Lime Down Solar Park

**Planning Inspectorate Reference:
EN010168**

**Wiltshire Council Comments on Submissions
Received at Deadline 5**

Deadline 6 (21 August 2026)

Drawing file: published-documents / EN010168-002318-6.2 ES Volume 2 Figure 3-4-1 to 3-4-2 Landscape and Ecology Mitigation Plan (Rev 3) (1 of 4).pdf

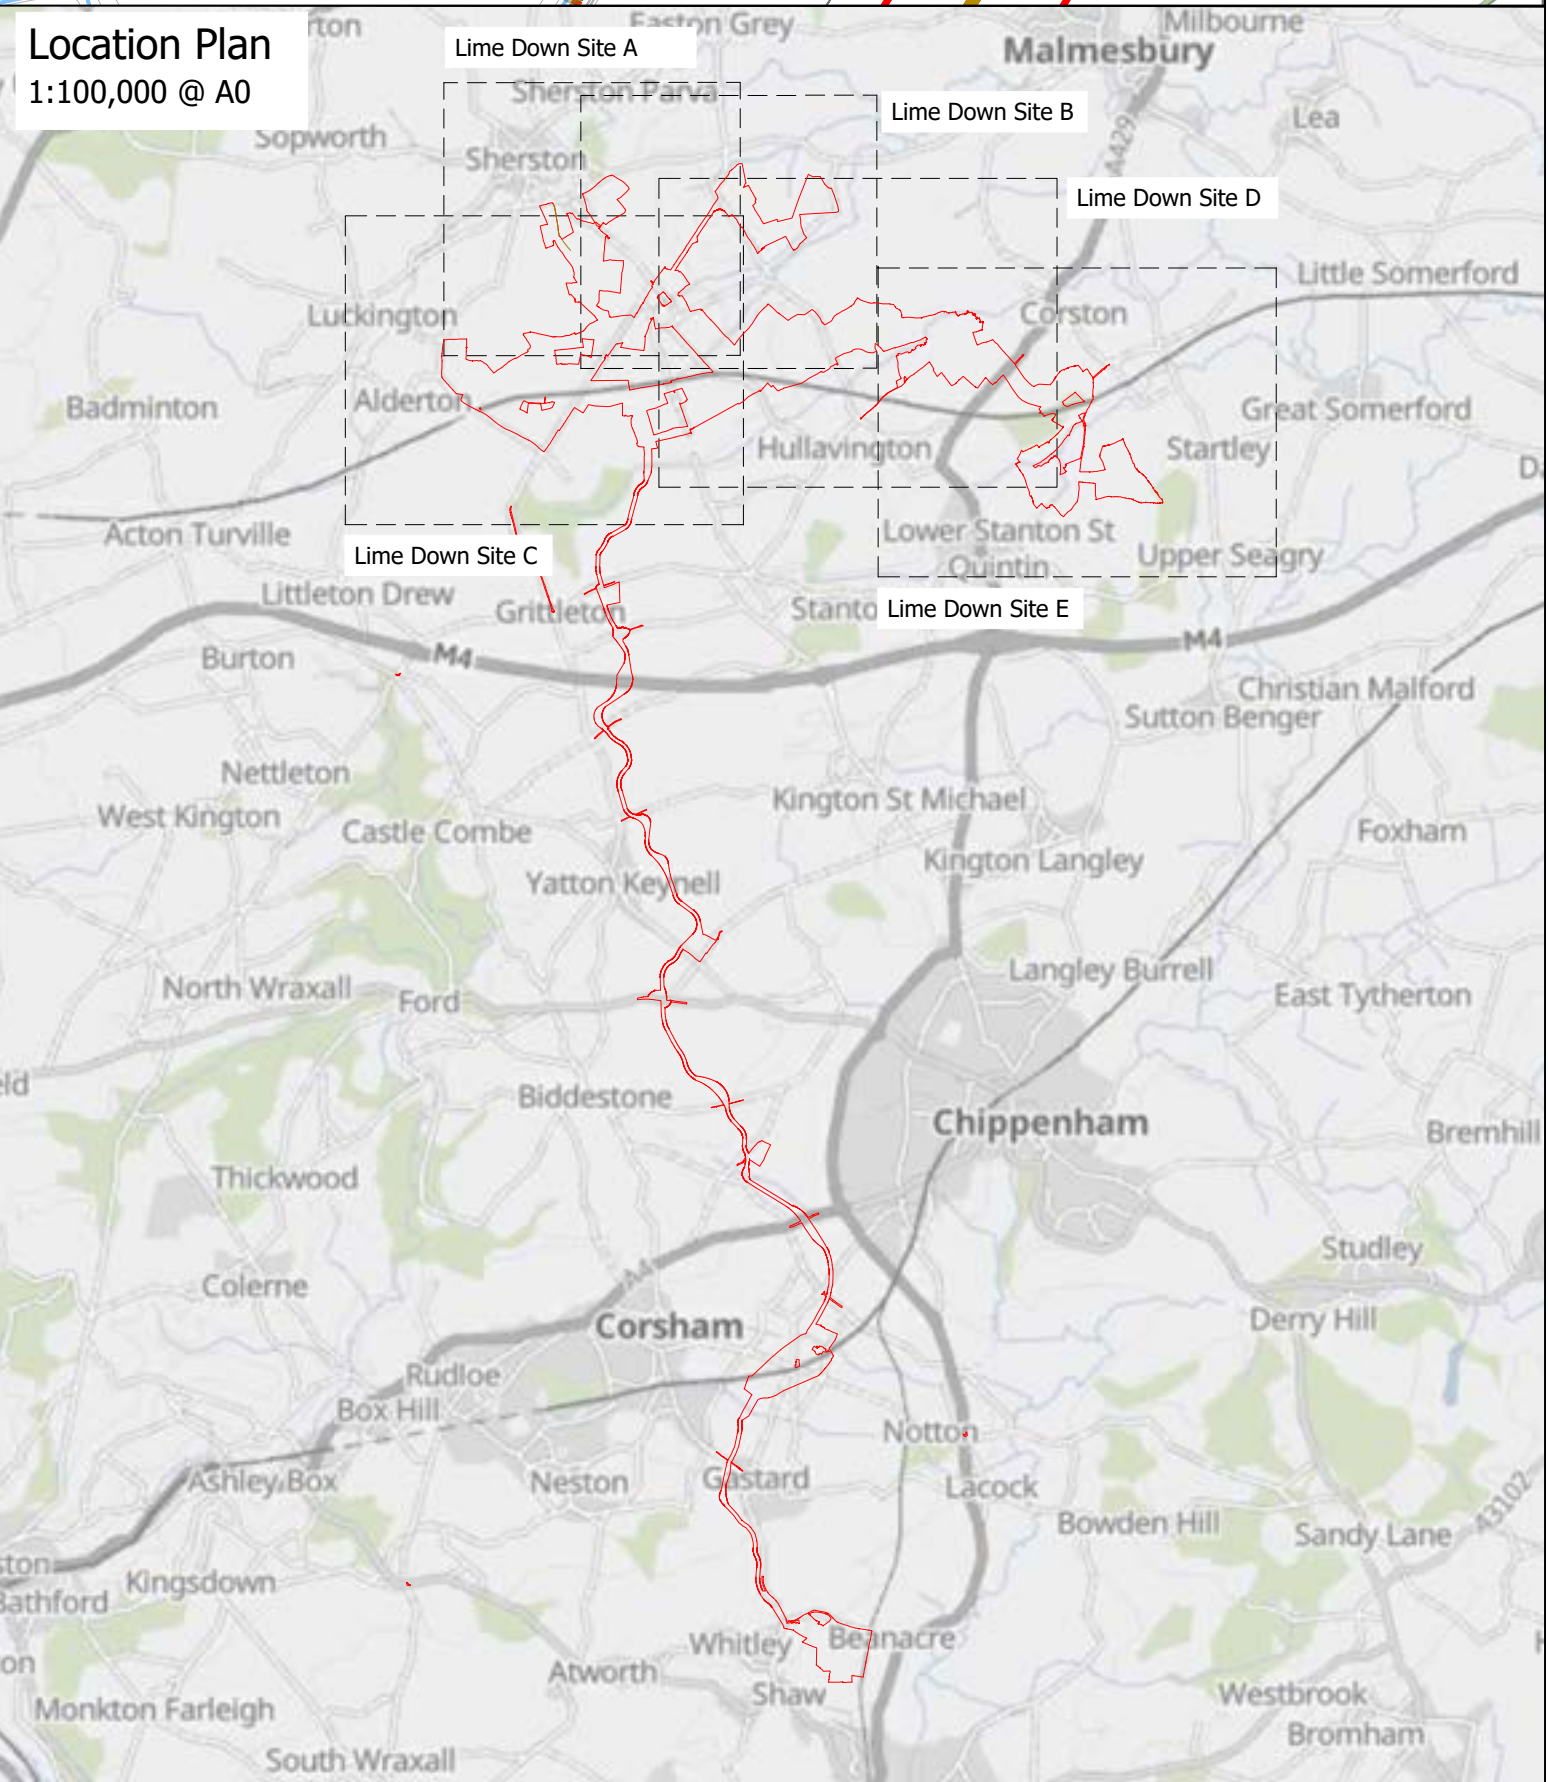
- 6.3. The Council is unable to locate specific locations to understand the extent to which the applicant is proposing to restore dry-stone walls within the setting of the CNL on the submitted Landscape and Ecological Mitigation Plan for Lime Down A [REP5-039] despite it being referenced on the key. The Council understands drystone walls are present along the eastern edge of field parcels A1 and A2, but they are not currently discernible. The Council believes the thin dashed brown line, is currently obscured by the thicker red line, denoting the order limit boundary. The Council considers it important to clearly identify where existing drystone walls are proposed to be restored on the 'Landscape and Ecology Mitigation Plan/s' and [REP5-039] revised to address this.

- 6.4. The Council additionally notes reference within the drawing key to '**existing drystone wall to be retained**' within the 'Landscape and Ecological Mitigation Plan' for Lime Down A [REP5-039]. The Council suggests that the current wording on this drawing key should be changed to '**existing drystone wall to be retained and restored**', alongside clearer visual identification on the plan to where these walls are located would provide greater planning certainty that the restoration of drystone walls will be delivered by the project and a clear link to Requirement 7 (Landscape and Ecological Management Plan) is secured.

Drawing file: published-documents / EN010168-002319-6.2 ES Volume 2 Figure 3-4-3.1 to 3-4-3.2 Landscape and Ecology Mitigation Plan (Rev 3) (2 of 4).pdf

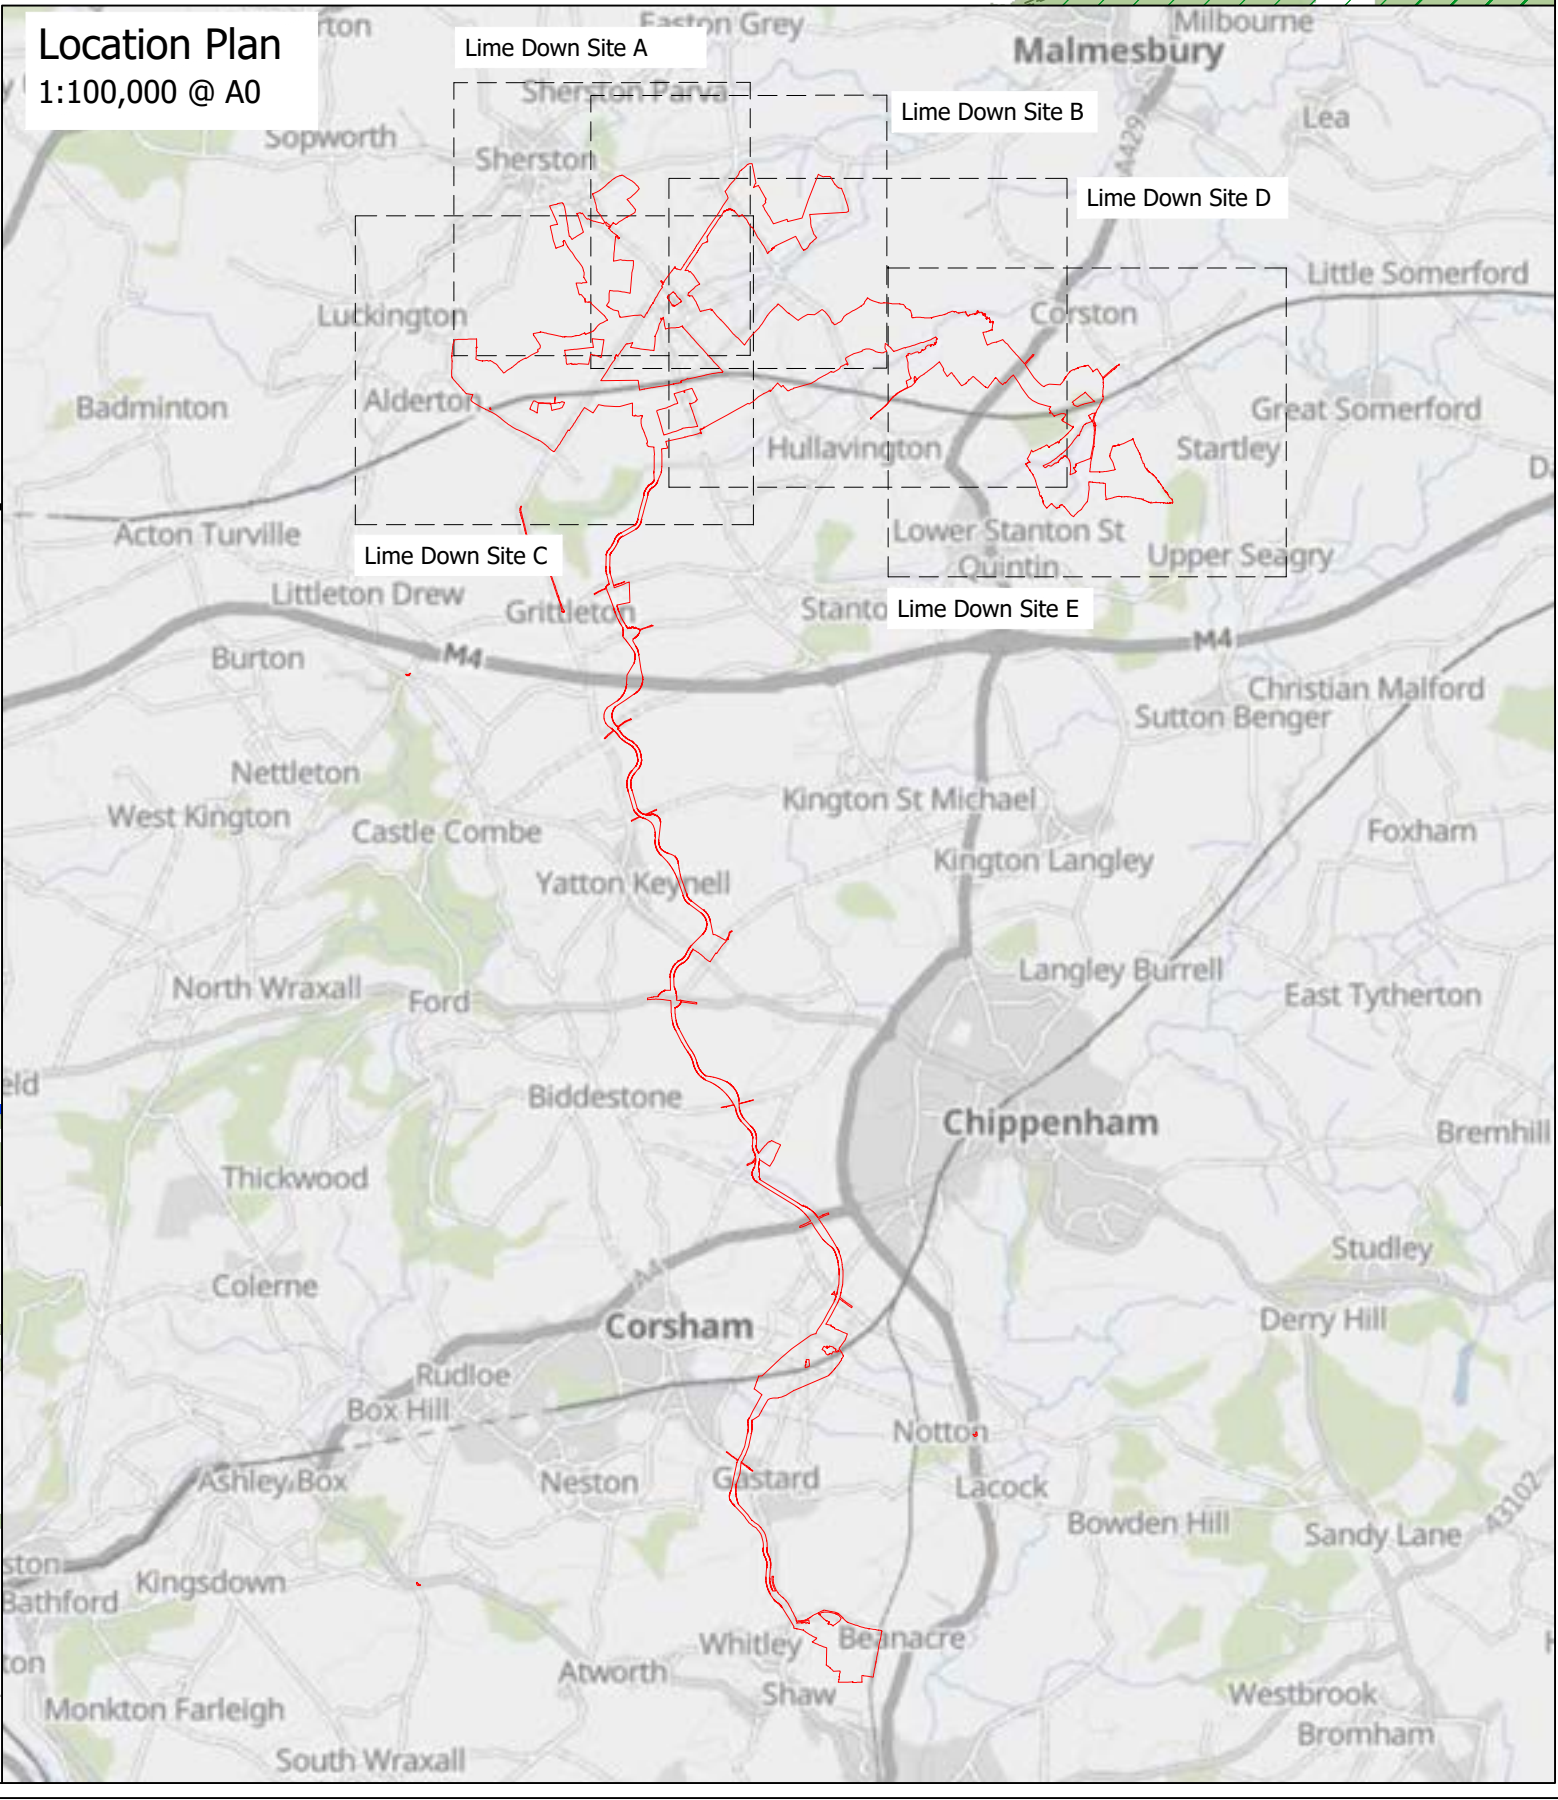
The Council considers that the 'Landscape and Ecological Mitigation Plans' **[REP5-039; 040; 041; 042]** should be revised to differentiate between the different internal access track / road functions, with different keyed line-type colours, as they are all currently the same light brown colour, so specific routes and the differences within illustrative construction details **[REP5-066]** are not clear on the plans. The Council suggests the following three types of internal access tracks could and should be separately keyed and illustrated on plans;
